Accessibility Review Report – DA Review

Project Title: Northside Gosford Private Hospital
Corner Racecourse Road & Faunce Street, Gosford

Date: 22 July 2020

Report Version: 9030_ADR_DA_v2.0

Figure 1 – Ground Floor Plan Mark-up

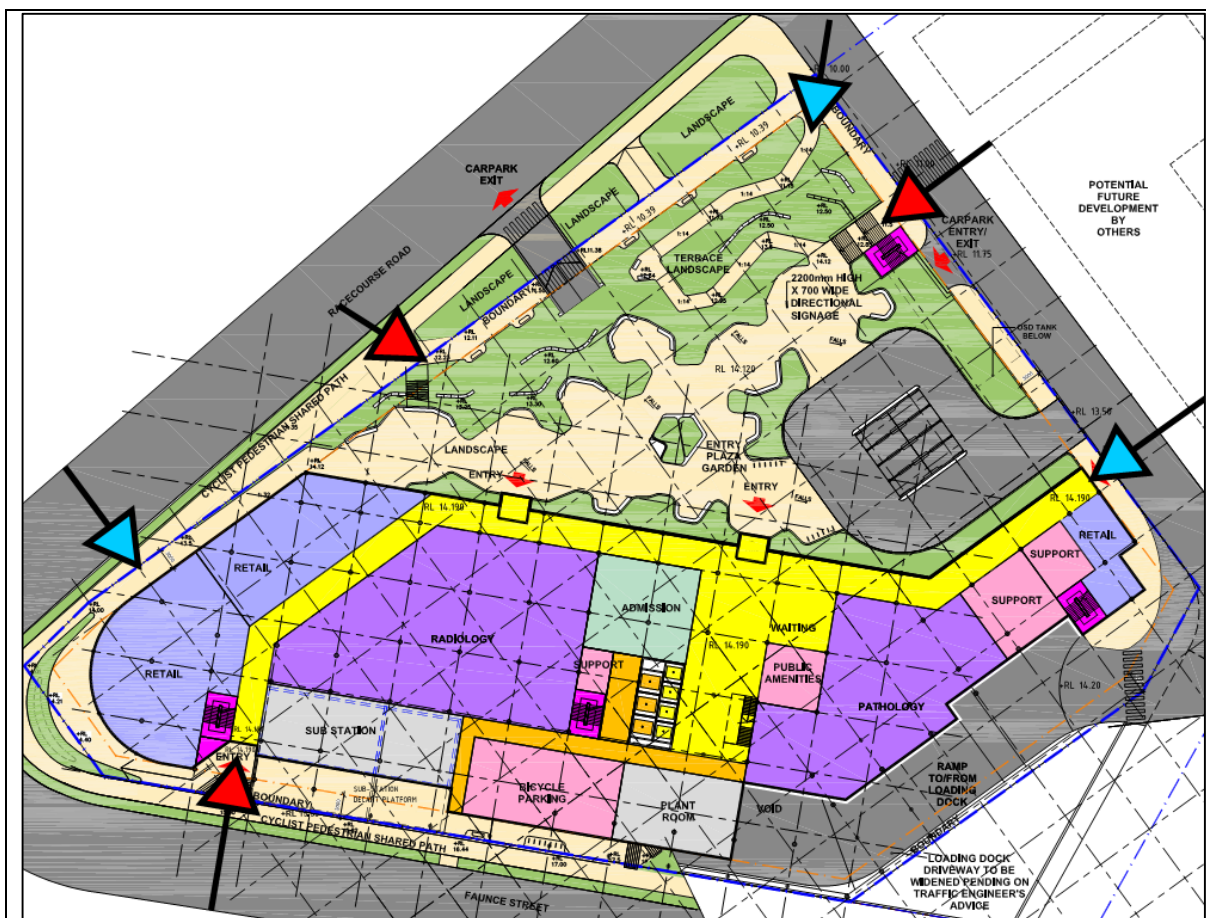
DtS Provision	Comment(s)/Recommendation(s)	Status
An accessway must be provided to a building required to be accessible – - from the main points of pedestrian entry at the allotment boundary; and - from another accessible building connected by a pedestrian link; and - from any required accessible carparking space on the allotment. In a building required to be accessible, an accessway must be provided through the principal pedestrian entrance, and – - through not less than 50% of all pedestrian entrances including the principal pedestrian entrance; and - in a building with a floor area more than 500m², a pedestrian entrance which is not accessible must not be located more than 50m from an accessible pedestrian entrance. except for pedestrian entrances serving only areas exempted by D3.4.	Accessways From Allotment Boundary Figures 1 & 2 below indicate the pedestrian entrances at the allotment boundary. - Blue arrow indicates an accessible accessway. - Red arrow indicates a non-accessible accessway. BCA Clause D3.2(a) requires an accessway to be provided from the main points of pedestrian entrance at the allotment boundary. <u>Performance Solution & Detail Design –</u> Due to the distance between the stairway and accessible entrance the following pedestrian pathways are considered to be a compliance departure: Ground Floor: 	DD & PS

RL's are indicated externally and internally at building entrances which indicates a step free access is achieved.

Figure 2 – First Floor Plan Mark-up

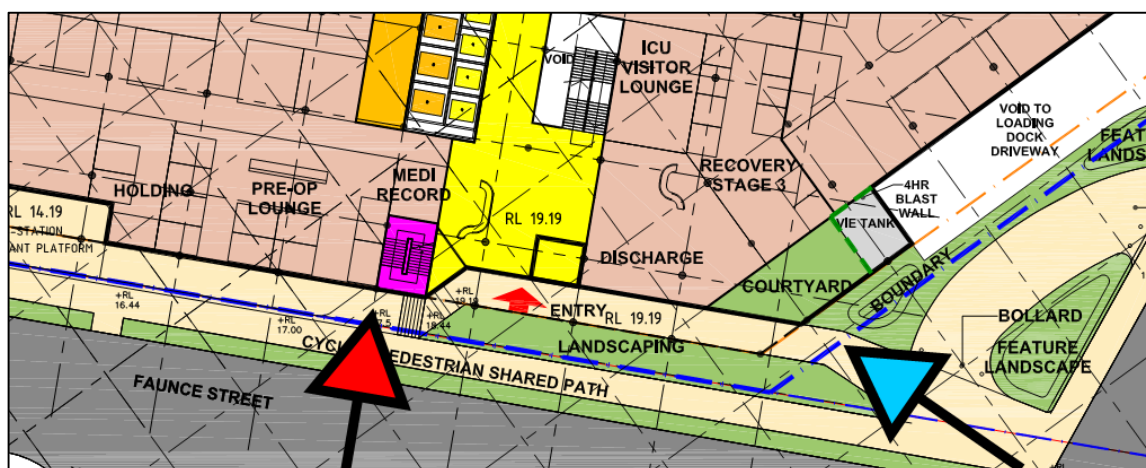
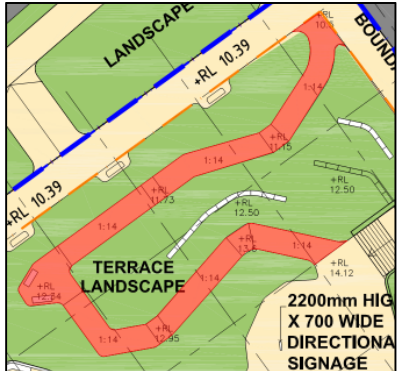
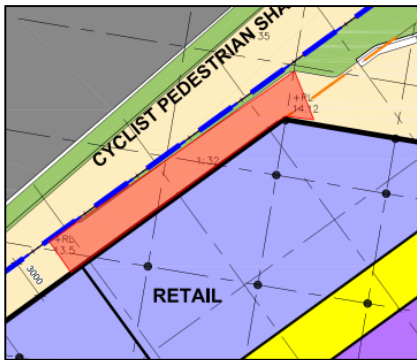
Level 1:
